Project No. 21101

**Re: PA22-024- Marysville 44th PRD – Technical Review 2
7315 / 7417 44th St NE – APN(s) 30053500303700 / 30053500303600**

This letter is provided as response to comments dated November 7 and November 8, 2022. Each item has been carefully reviewed and considered and the following is a summary of how each item was addressed.

DRAWING: C9
 SHEET: 9 OF 9

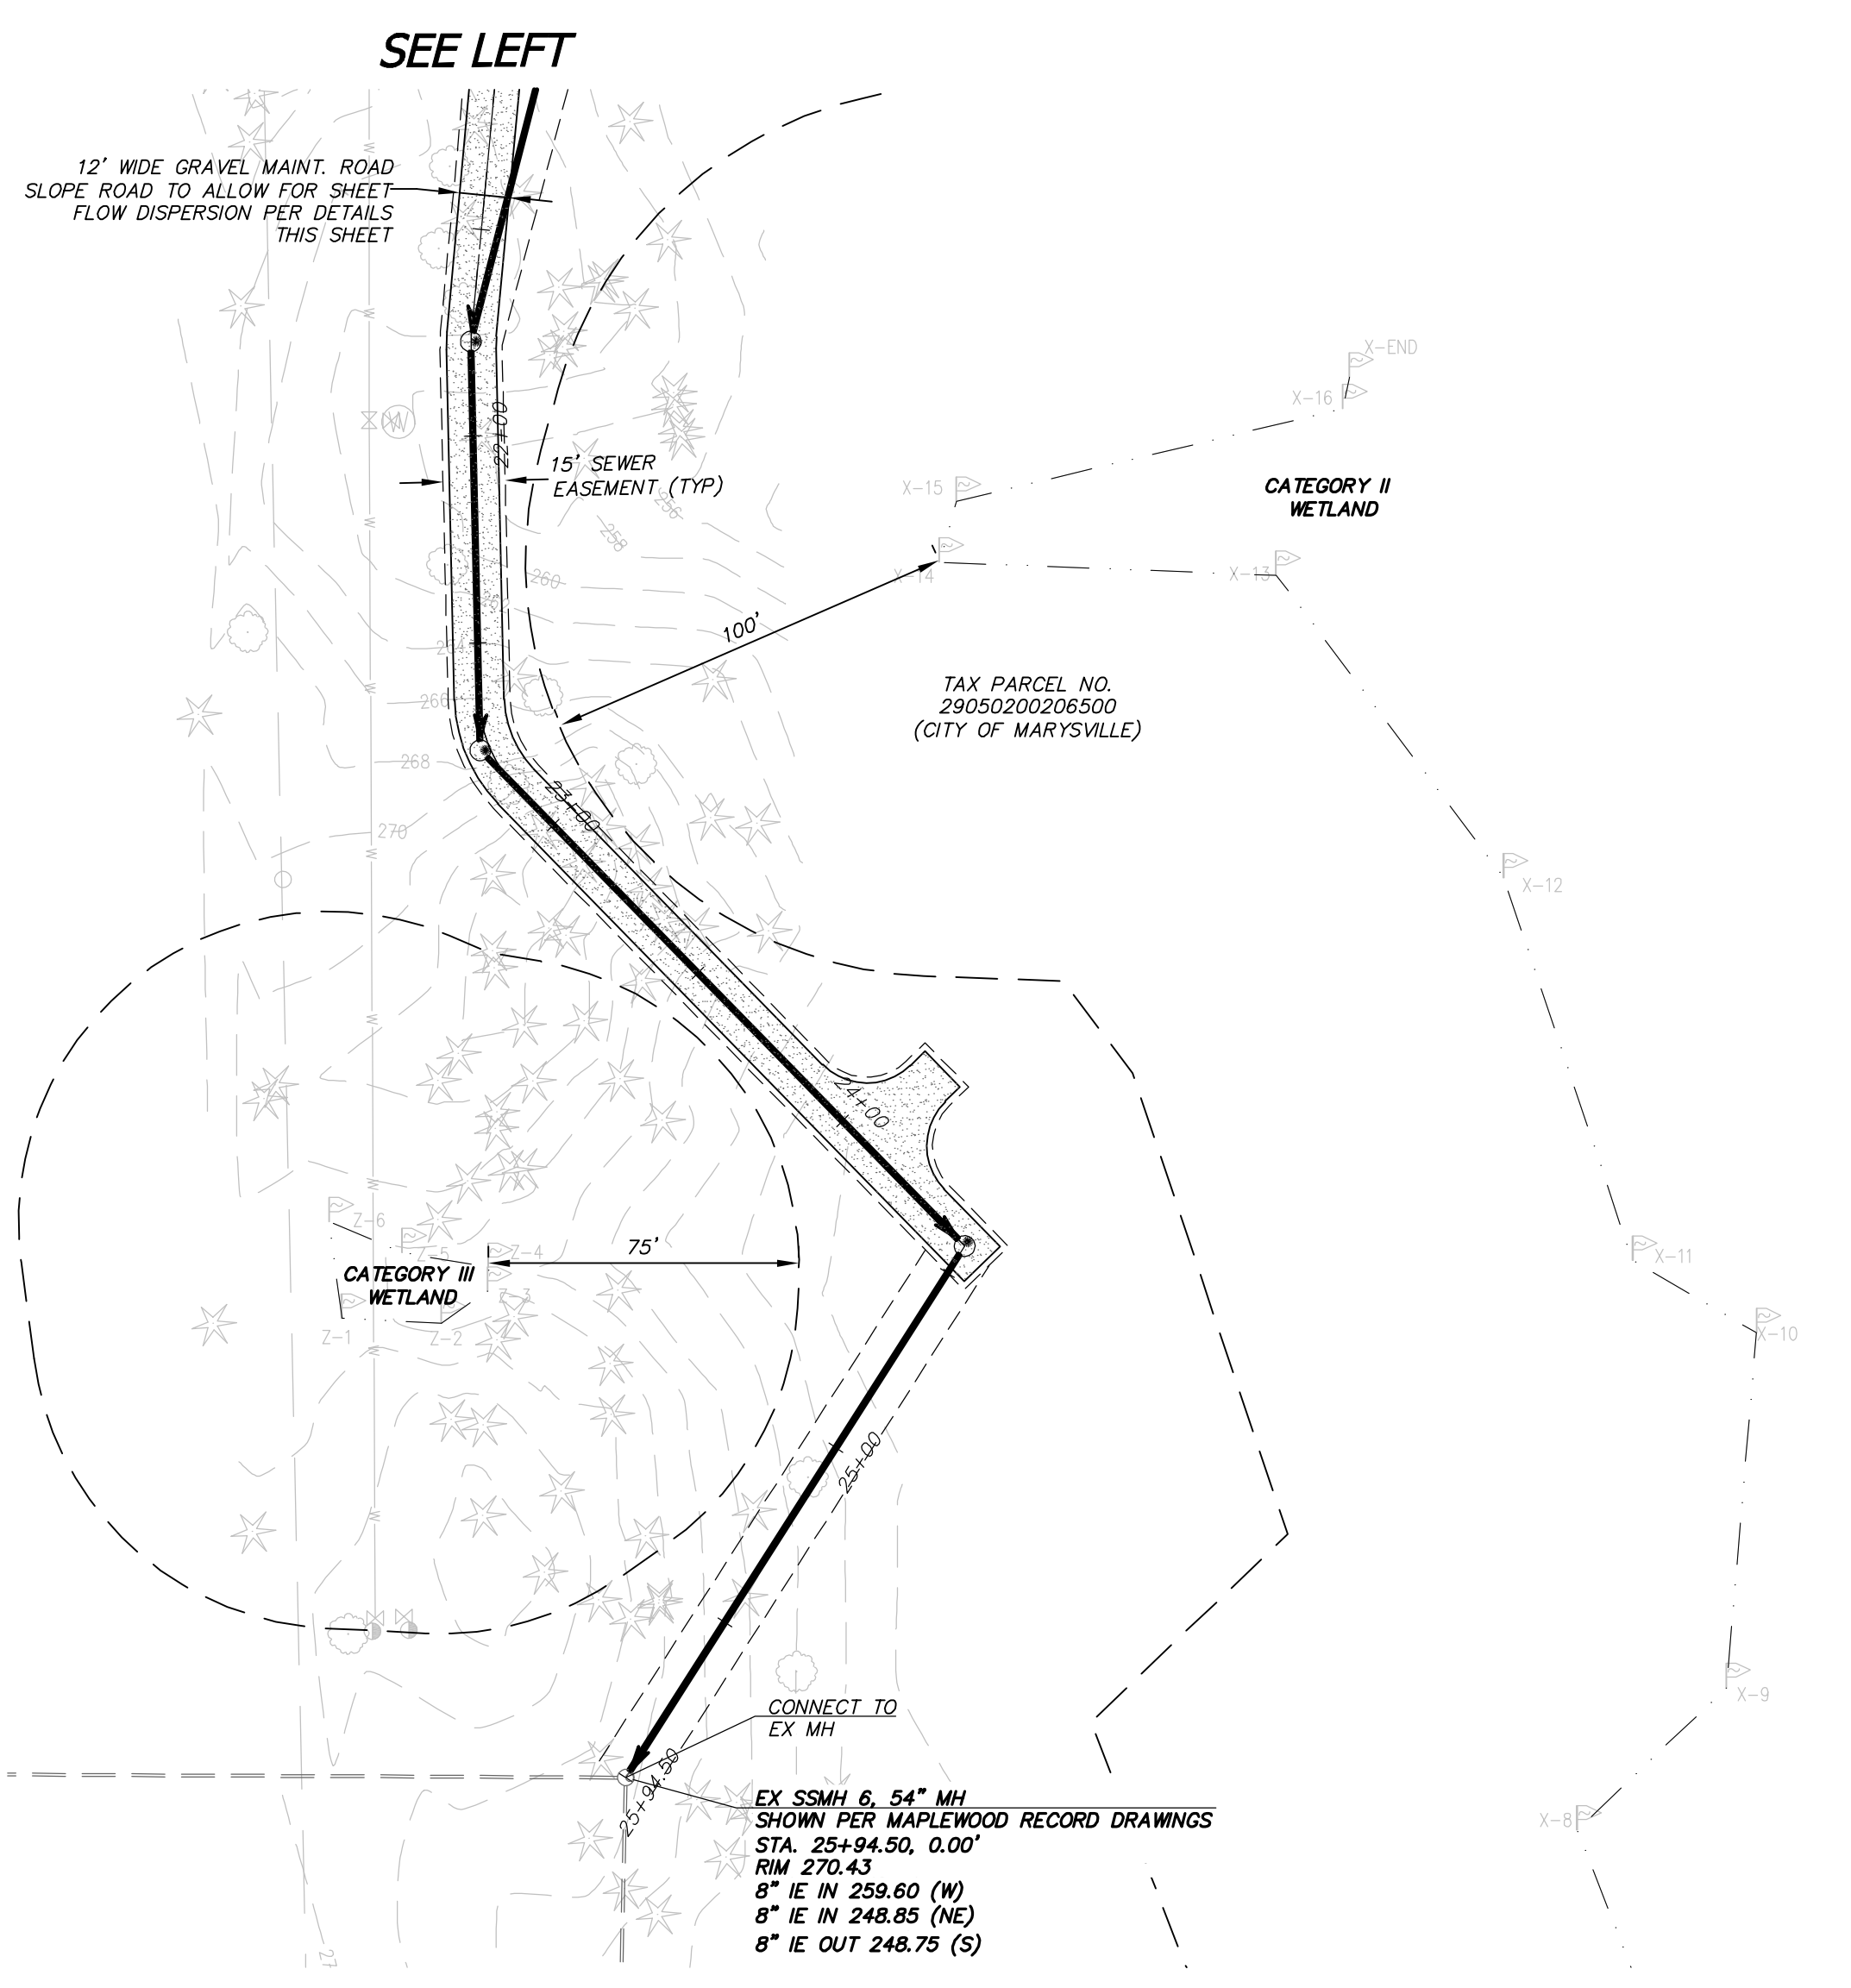
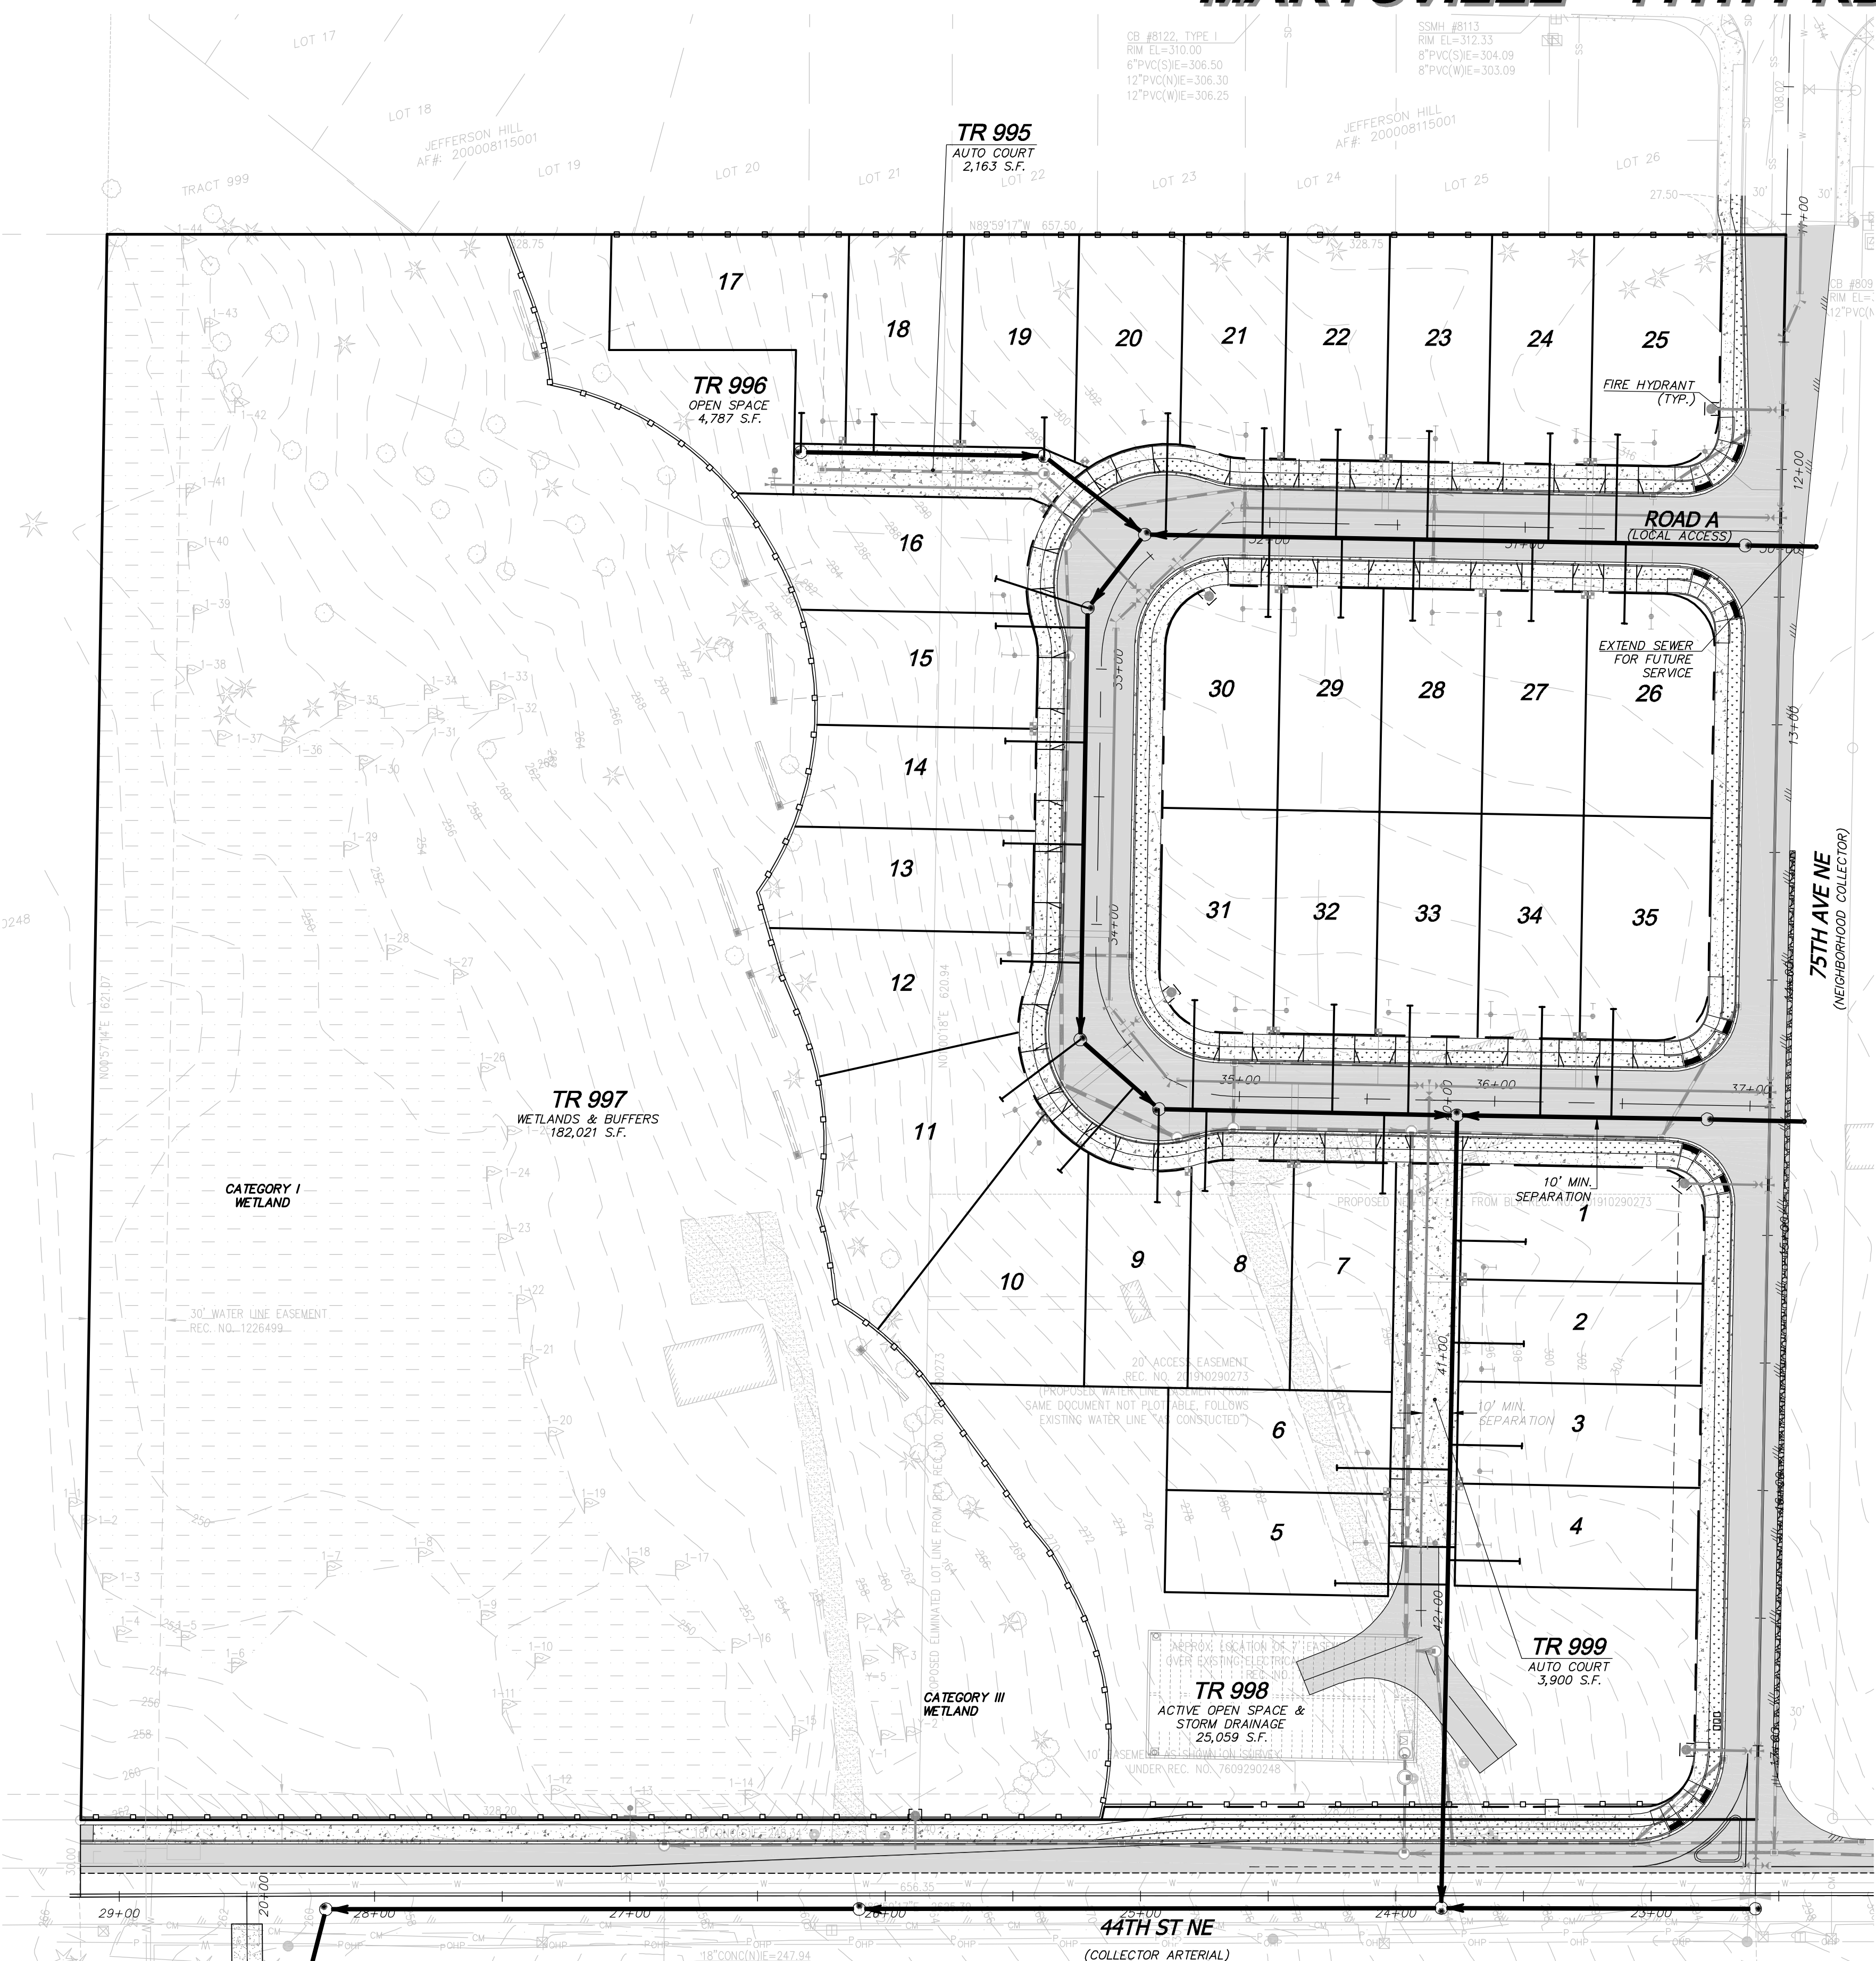
1. Per MMC 14.03.250, utilities are to be extended along the street frontages of the proposed project.
 - a. It doesn't appear that the sewer was extended 50' to the east to 75th Ave NE to service parcel number 00590700018101.

Sewer is extended now.
